Re: Drainage Plan Resubmittal - Keleher Executive Center

This resubmittal is in direct response to your review letter of November 15, 1985 regarding this site (reference J-14/D56). Our responses correspond with the items as denoted in your letter (copy attached).

**DUPLEX SUMP PUMP & BASIN DETAIL**

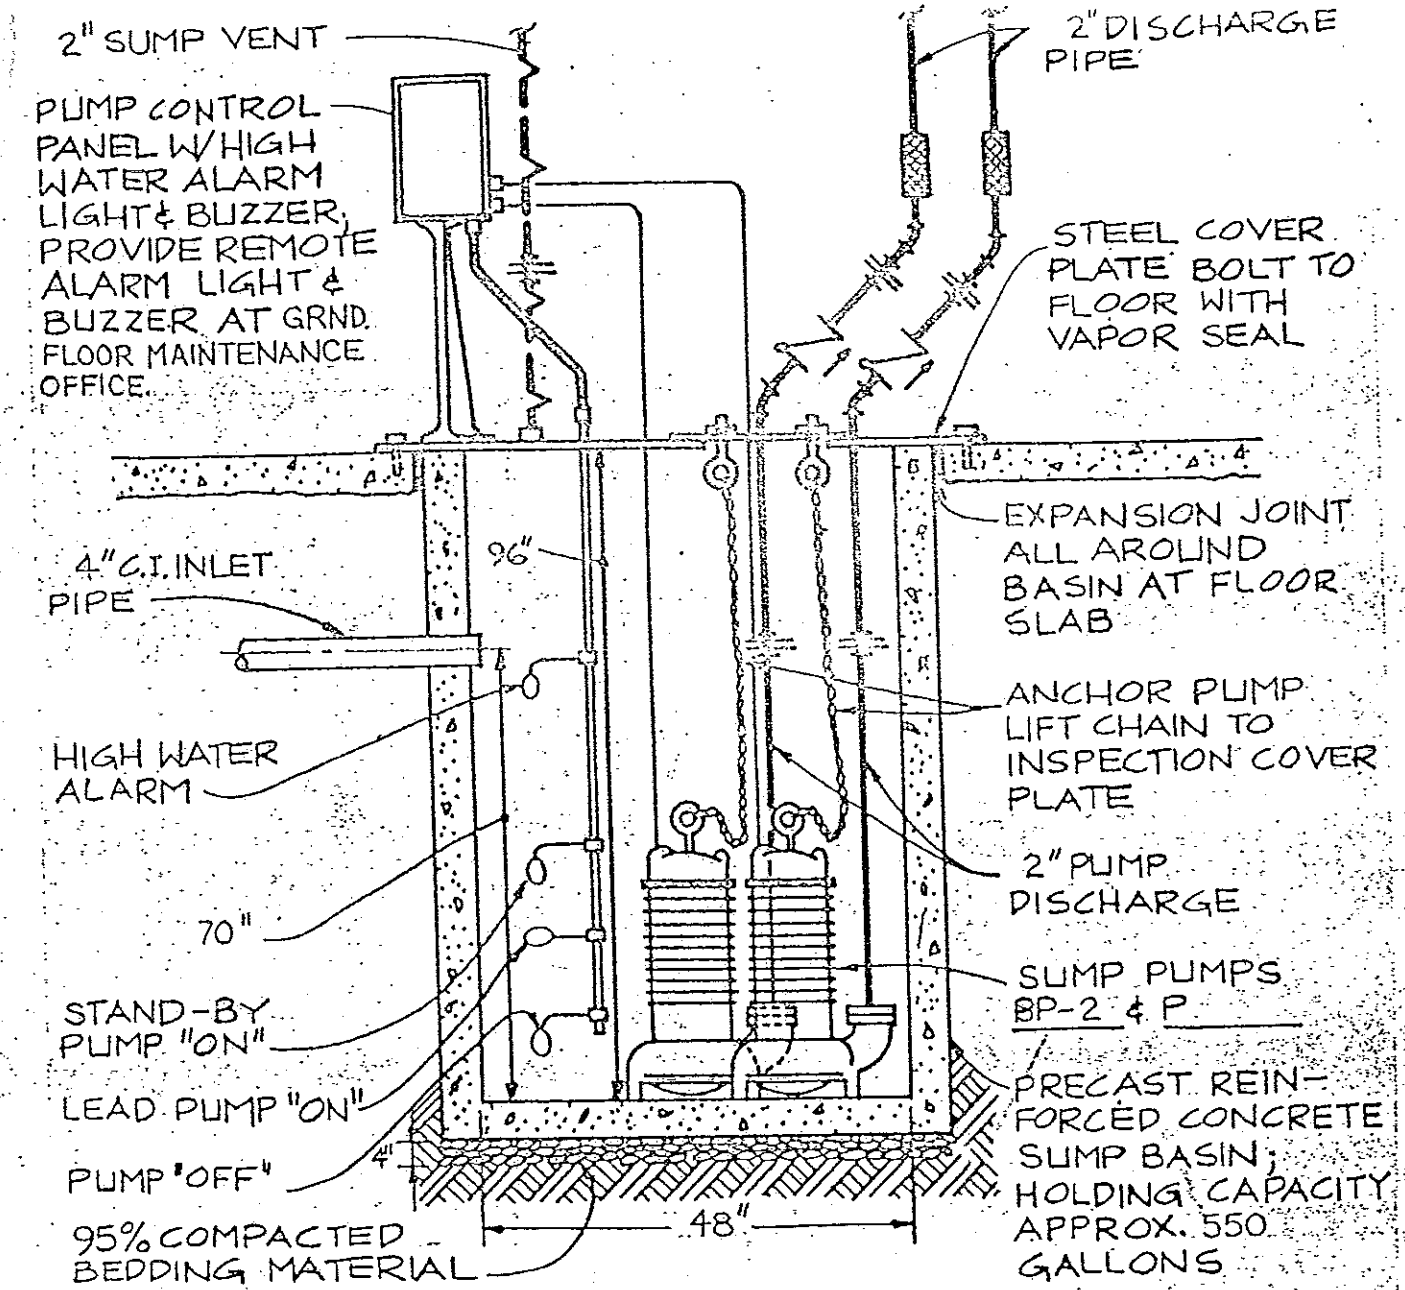
- ✓ 3. Runoff volumes of the various drainage areas are now shown in the computations portion of the Appendices.
- ✓ 4. The pump details (in Appendix B) show check valves on the discharge line of each pump.

**GRADING AND DRAINAGE PLAN**  
**LOWER LEVEL**  
SCANLON & ASSOCIATES  
CONSULTING ENGINEERS

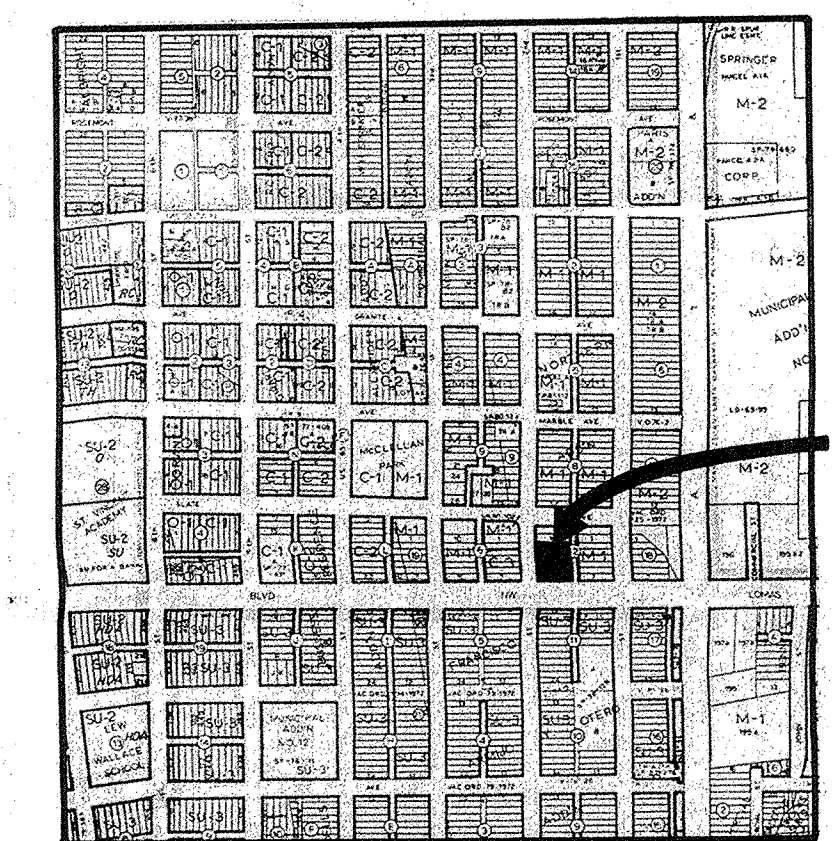
- ✓ 1. We have raised the lower level parking ramp to provide 2 ft. of flood depth from the street gutter.
- ✓ 2. We have provided an additional Appendix B to the Drainage Plan which provides the submersible pumps. These pump details and specifications were taken directly from the mechanical portion of the plans and specifications for the building. We have also added hydraulic computations to clarify the hydraulic situation these pumps encounter.
